**KIRKLEES METROPOLITAN COUNCIL
INVESTMENT & REGENERATION SERVICE**

DELEGATED DECISION TO DETERMINE PLANNING APPLICATIONS

Reference No:	2025/62/91445/E
Site Address:	Land Adj, 26, Haigh Lane, Flockton, Huddersfield, WF4 4BZ
Description:	Erection of timber building storage building with animal stalls
Recommending Officer:	Nina Sayers

DECISION - REFUSED

Plans and elevations

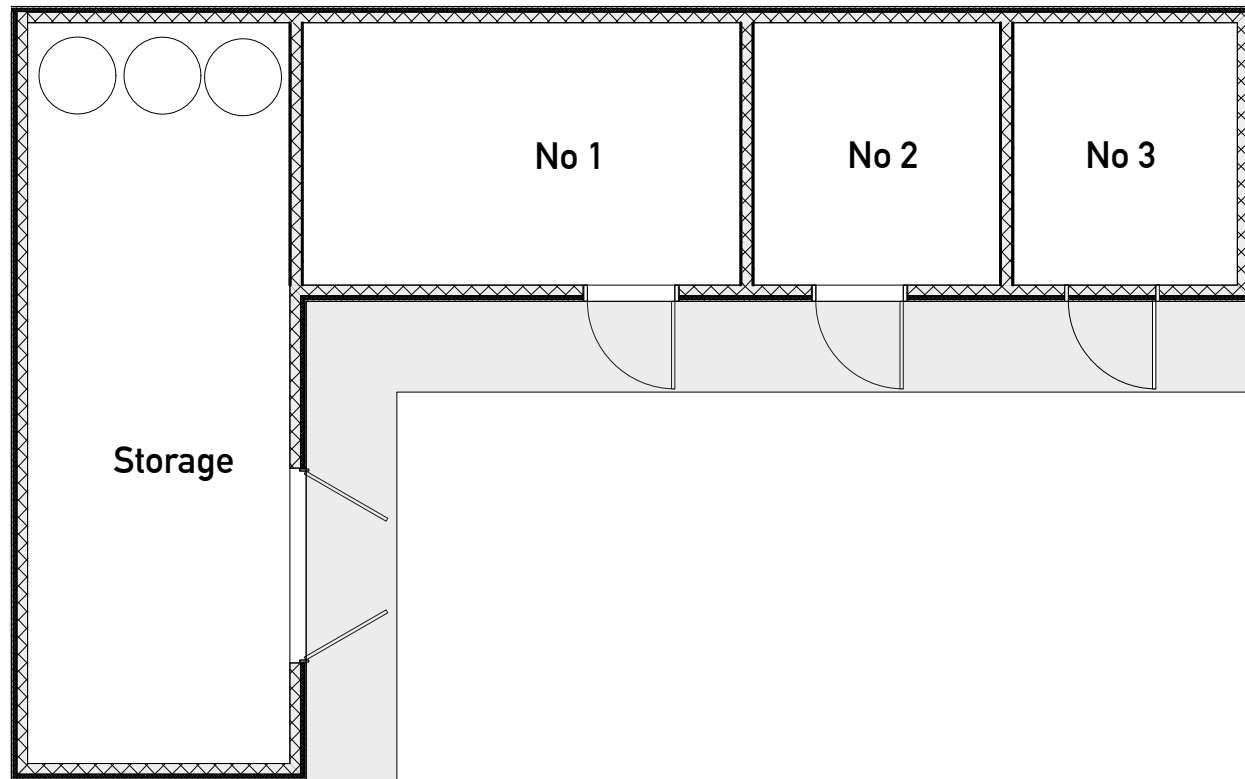
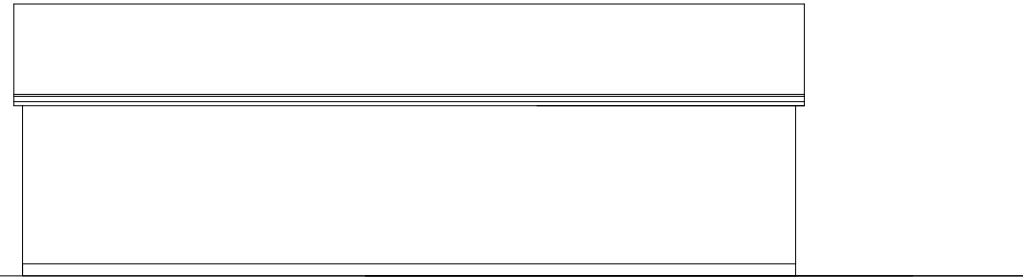
Initially the proposed building covered a floor area of ~108m² and the applicant did not provided a justification for the scale of proposed building nor did the applicant explained why the building need to be sited in this location. These concerns were raised with the agent, and the building was reduced in scale and moved north-east, in a similar location to the existing container. An additional supporting statement was also submitted which details “the new building will be used for the welfare and shelter of a small flock of sheep, particularly during lambing season and adverse weather conditions.”

In terms of justifying the size of the building proposed, the submitted details state “It is modest in size and scale, proportionate to the needs of the holding, and does not conflict with the purposes of including land in the Green Belt.” The agent outlines that the recommended area is 1x2m per sheep plus an area for storage. “I have shown space for up to 6 sheep however the client would only be keeping 4 to 5 sheep in this unit. But I have left space to enable separation if a sheep was required to isolate”.

It is not clear where the ‘recommended area’ of 1x2m per animal has been drawn from. However, on this basis, the agricultural use of the site would require 10m². Whilst officers are willing to accept some additional floor area if sheep are required to isolate, and for storage, the proposed building is ~50m² which is significantly larger than the floor area required by the agricultural use, as outlined by the agent. Therefore officers believe that insufficient information has been provided to demonstrate that the building is genuinely required for the purposes of agriculture and therefore officers considered that the proposal would fail to comply with LP54(a).

Taking the above into account, it is considered that it has not been adequately demonstrated that the building is genuinely required for the purposes of agriculture, thus failing to comply with LP54(a) of the Kirklees Local Plan. On this basis the application would also fail to fall under exception a of paragraph 154 of the NPPF.

As detailed above the proposed building would introduce new development in the green belt which is considered inappropriate. The scale of the building is disproportionate to the use outlined. A new building of this scale, in this location, with no justified reason, would detract from the open nature of the green belt setting and therefore would cause harm to openness and visual amenity of the rural setting of the application site.

1. Insufficient information has been provided to demonstrate that the building is genuinely required for the purpose of agriculture and no justification has been provided for its excessive scale, thus failing to comply with LP54(a) of the Kirklees Local Plan. On this basis the application would also fail to fall under any of the exception detailed in paragraph 154 of the NPPF. The development would therefore be inappropriate development within the Green Belt and harmful to the openness of the Green Belt, contrary to the policies within Chapter 13 of the National Planning Policy Framework and Policy LP54 of the Kirklees Local Plan. Very special circumstances to clearly outweigh the harm caused to the Green Belt by reason of inappropriateness and any other harm, as required by paragraph 153 of the National Planning Policy Framework have not been demonstrated.
